## MMC Office Building Final Traffic Comments

Hi Nell – The following is a status update on prior comments and represent Final Traffic Comments. I have separated the comments that are associated with issuance of a Traffic Movement Permit.

3. NO PARKING SPOTS ON NORTH SIDE OF CONGRESS STREET
4. TURNER NEEDS 10 FEET ON GILMAN STREET.
5. REFER TO CMP SECTION 3.0 FOR GARAGE REMOVAL METHODOLOGY.

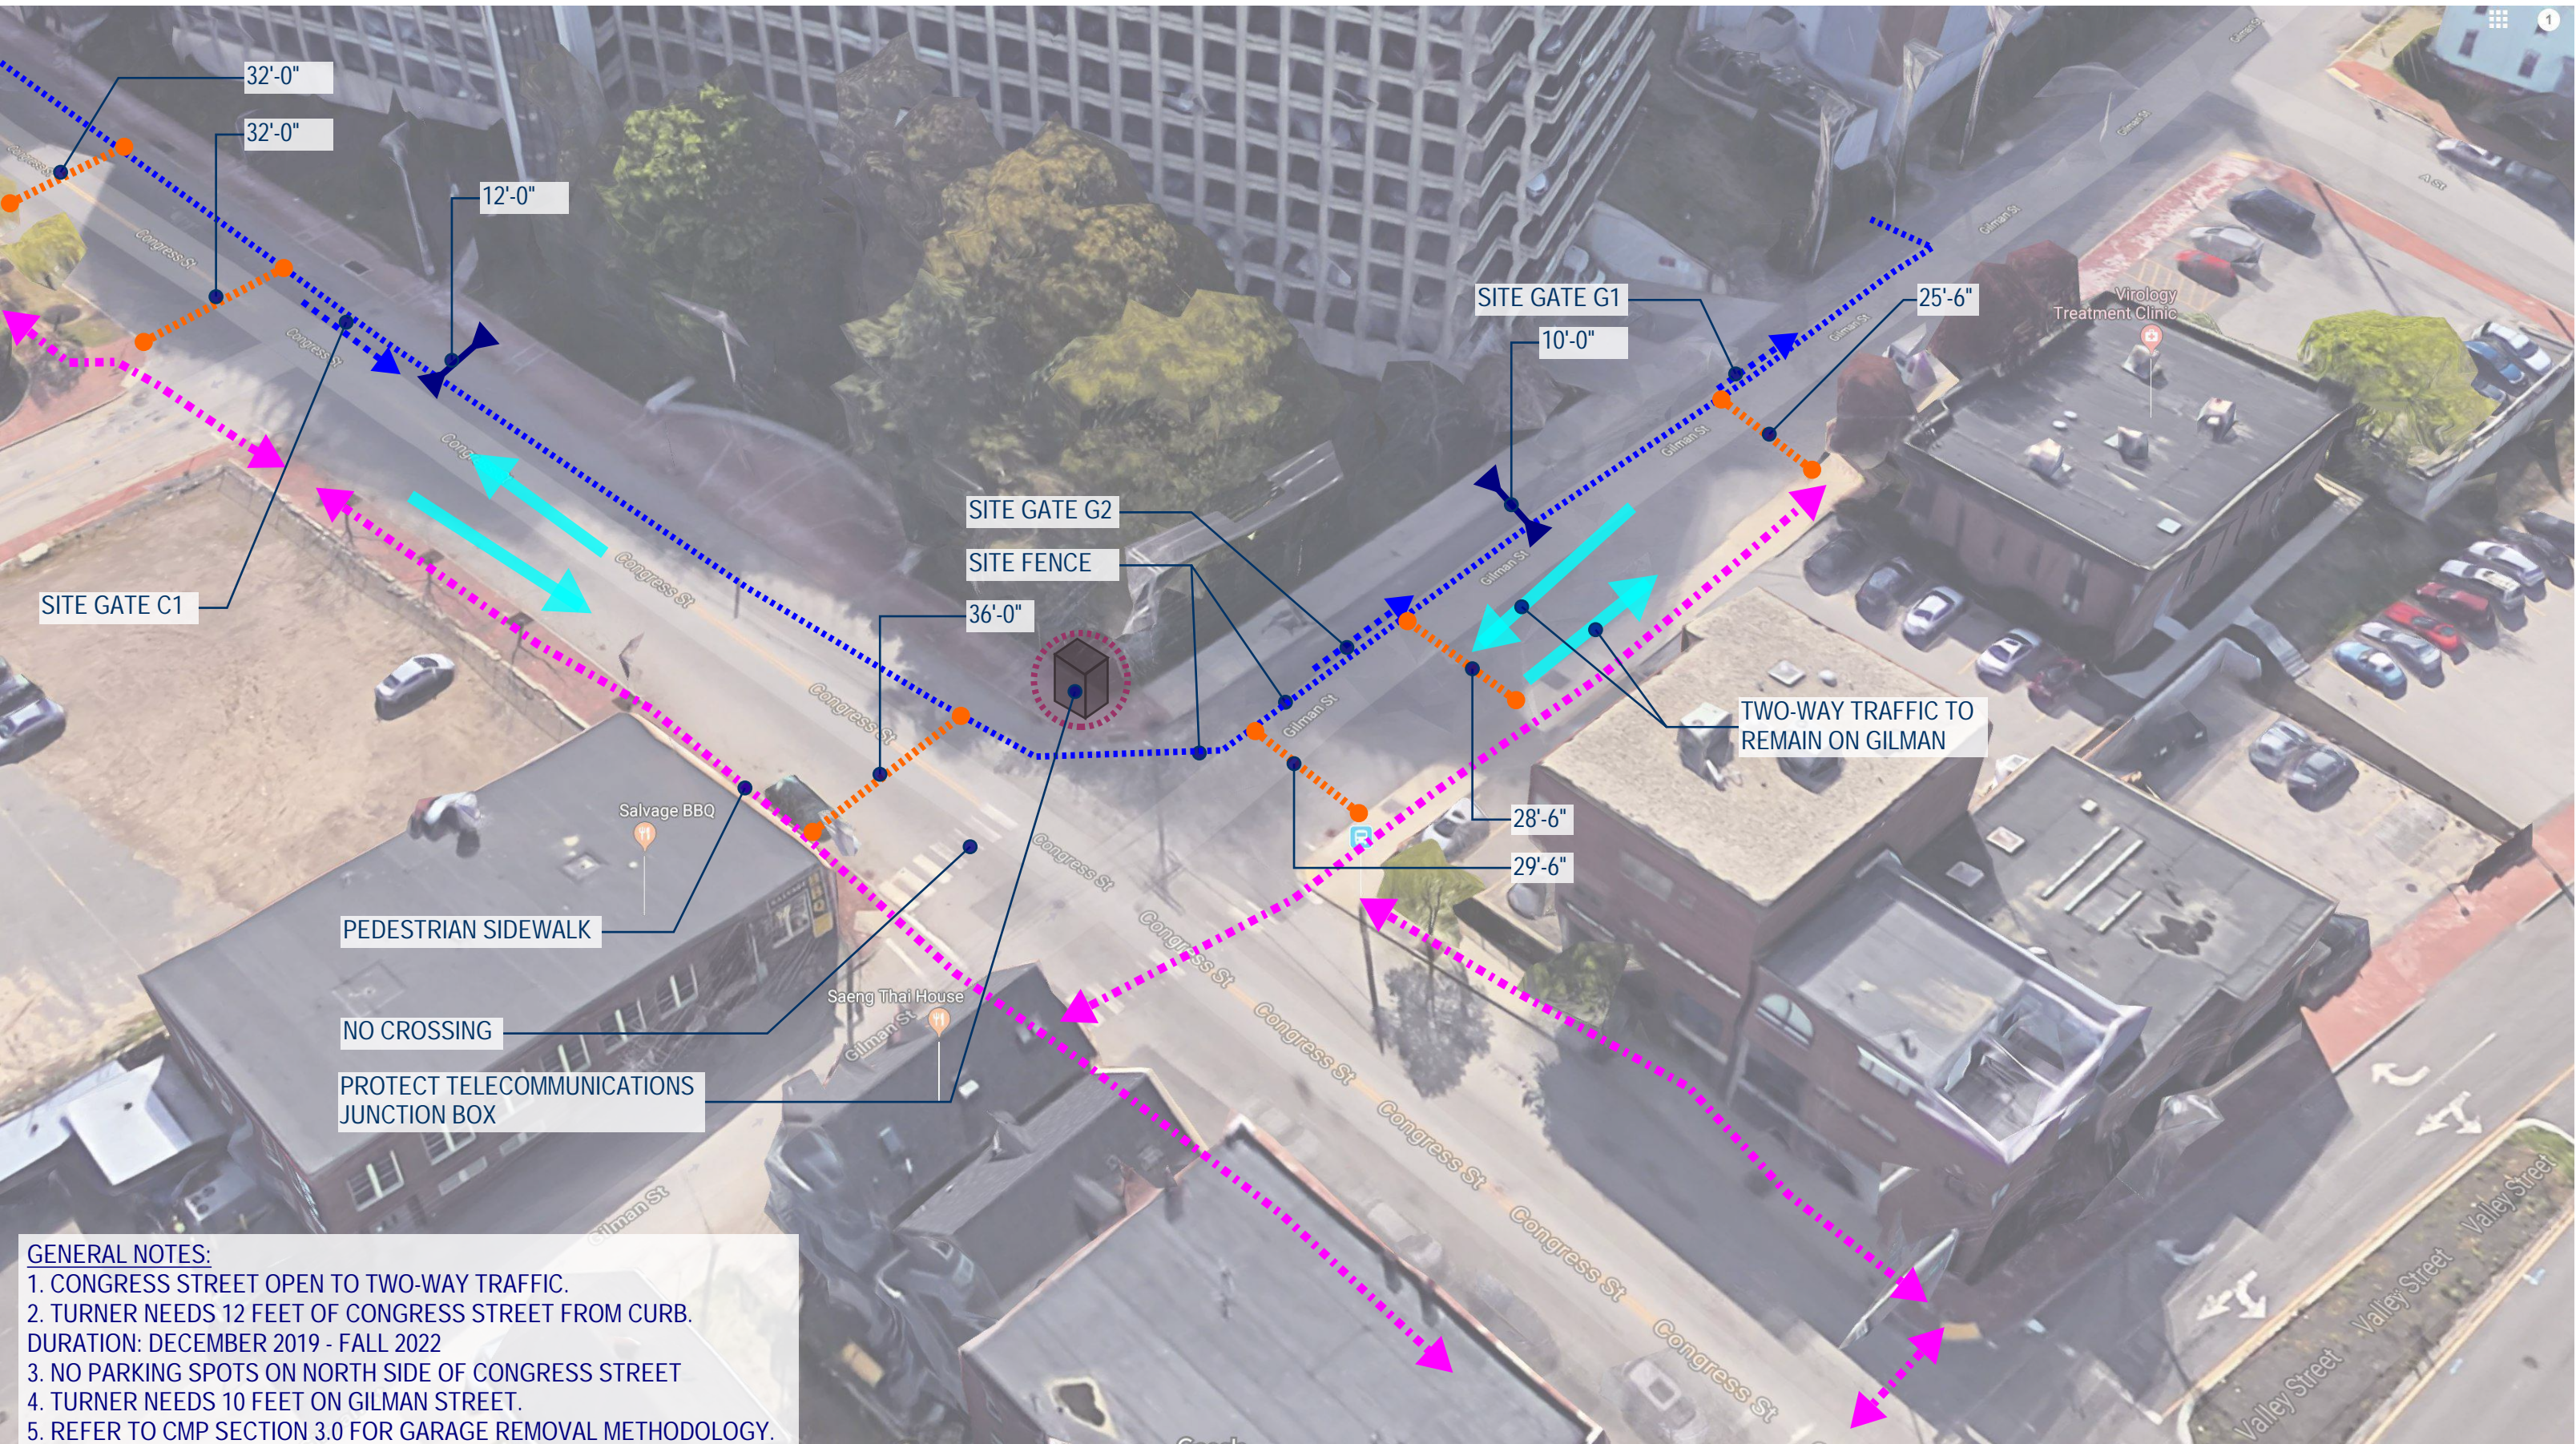
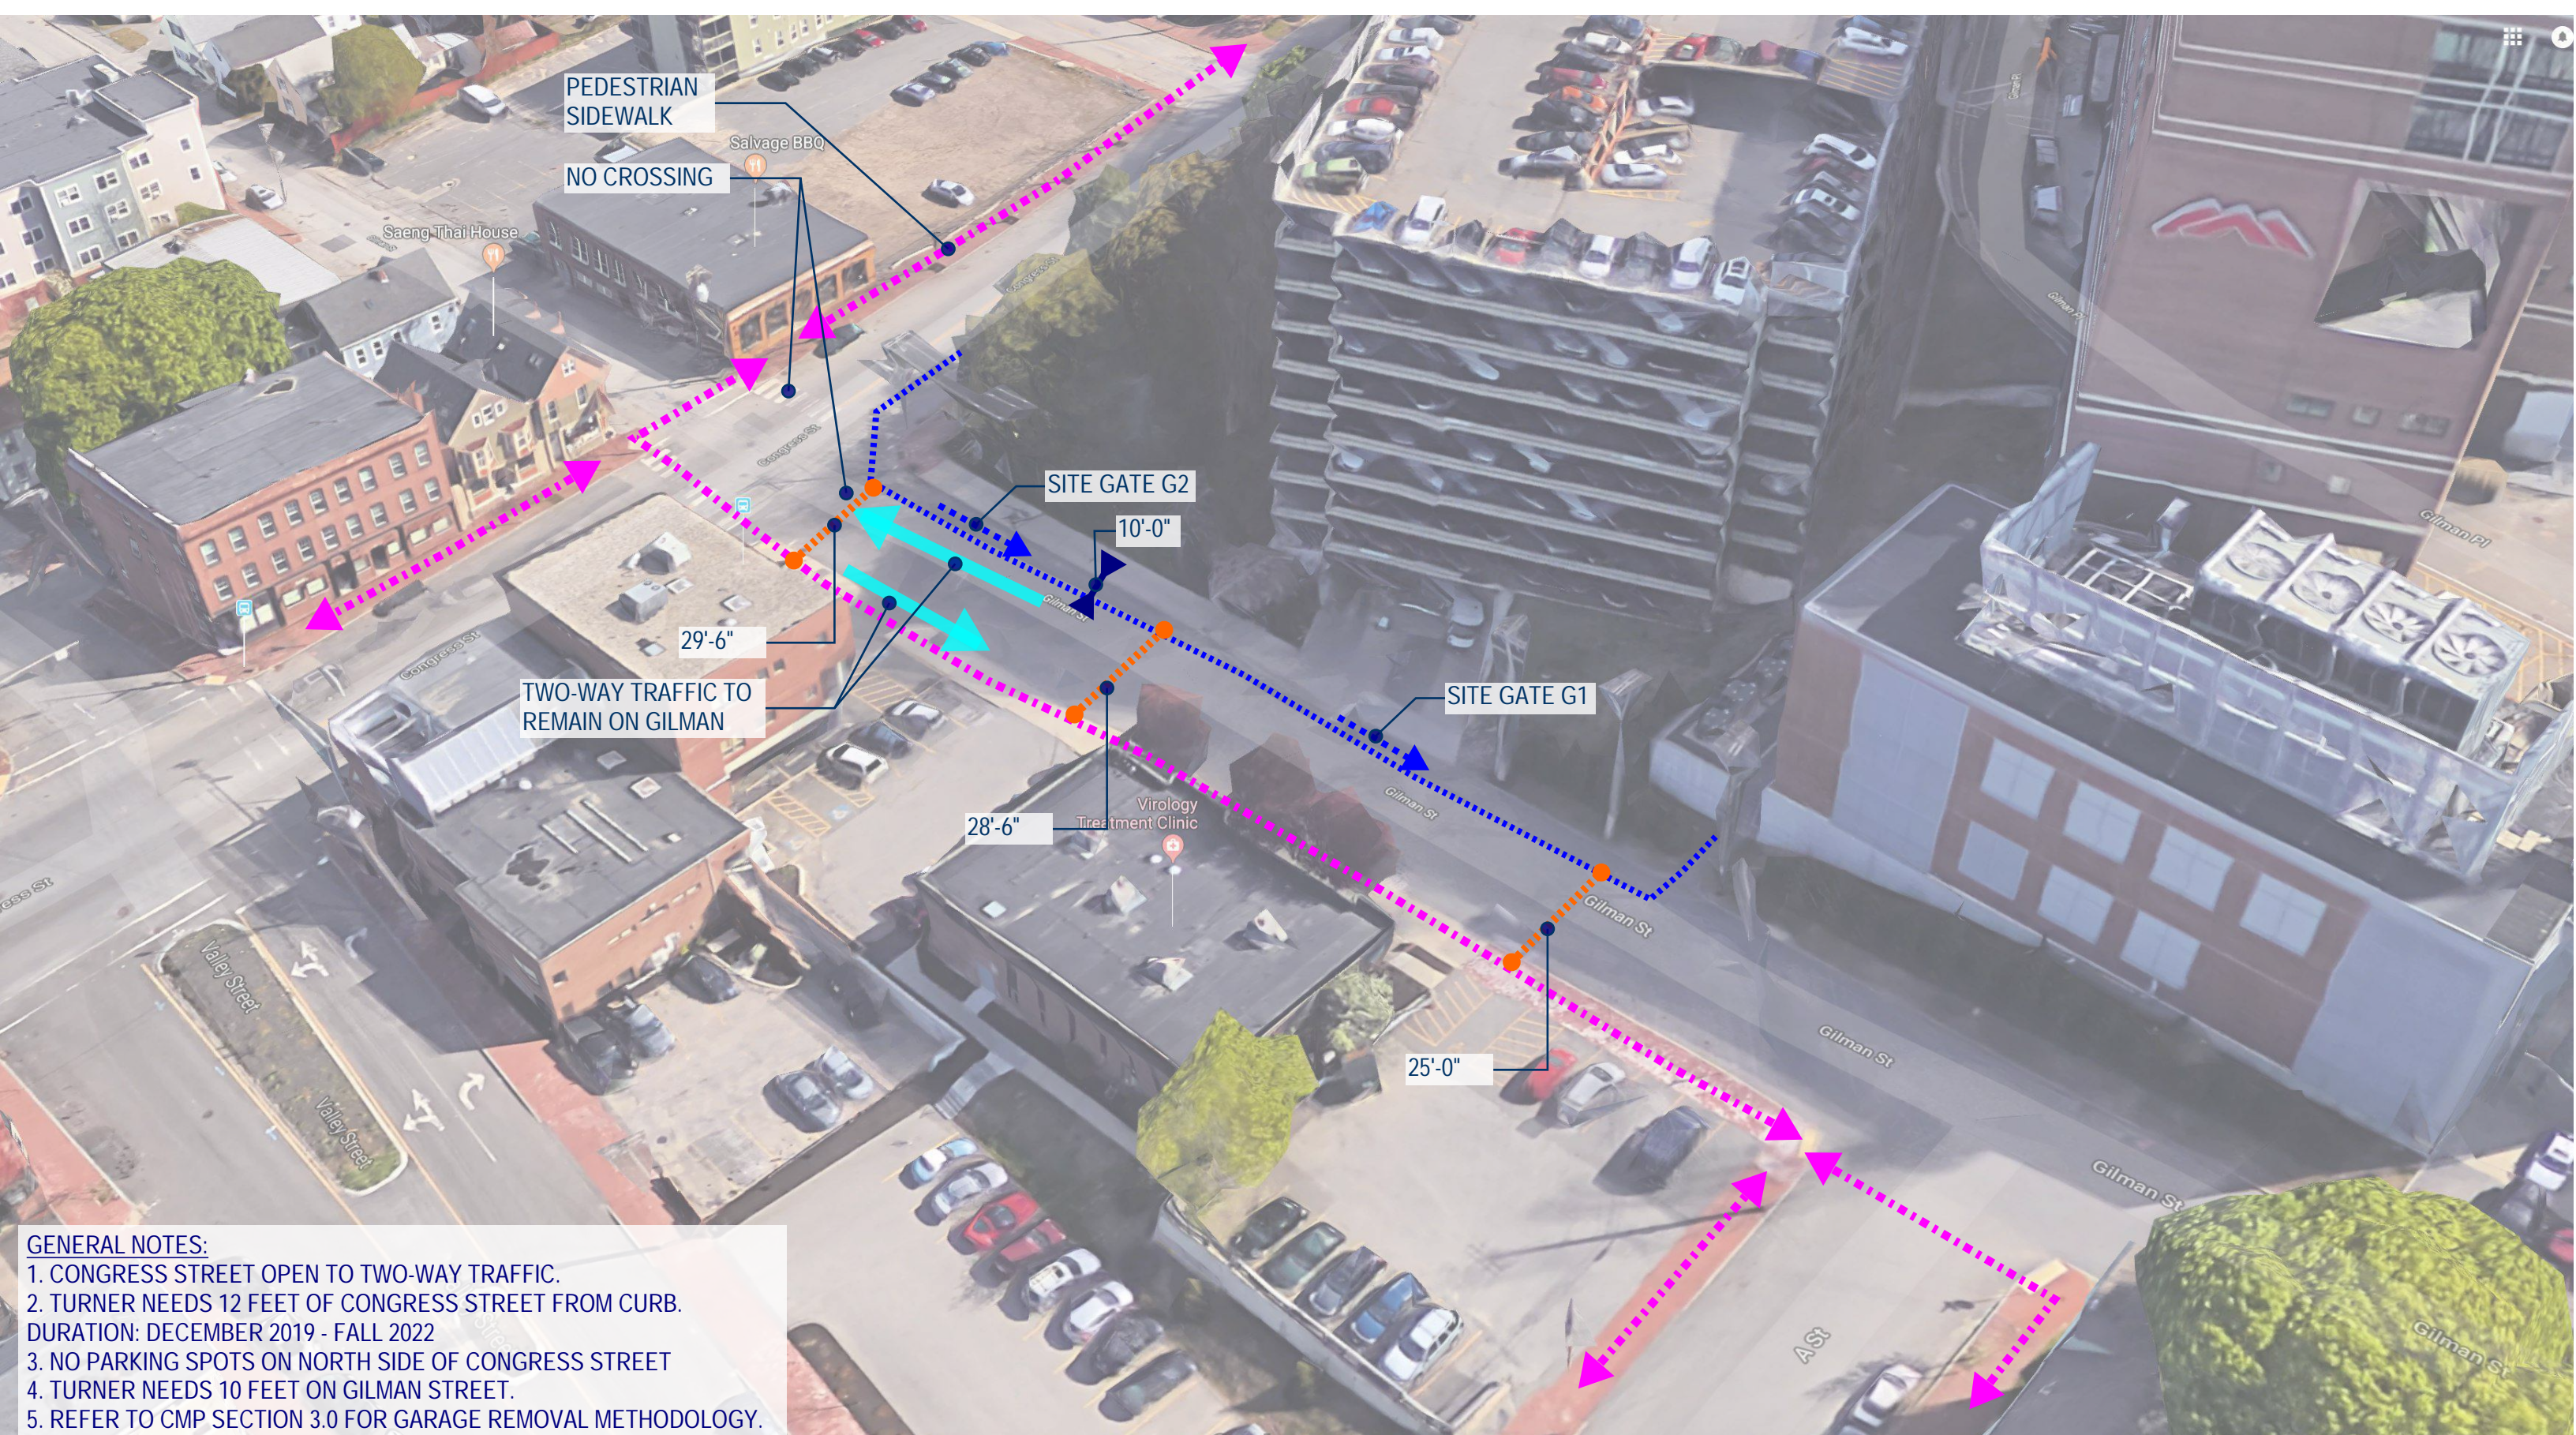
- **I have reviewed the Construction Management Plan and generally find it to be acceptable. Some specific comments:**
  - **It is recommended that further discussion on the duration of the Congress Street sidewalk closures be included.**
  - **Supplemental pedestrian safety devices will be required during the sidewalk closure time period (to safely cross pedestrians for the sidewalk detour).**
  - **All sidewalk detours shall be ADA compliant.**
  - **Changes to the lane configuration on Congress Street west of Gilman Street is likely and may need to be included in the plan.**
  - **A significant amount of construction activity will be required for utility and street construction work and specific plans shall be development for review and approval.**
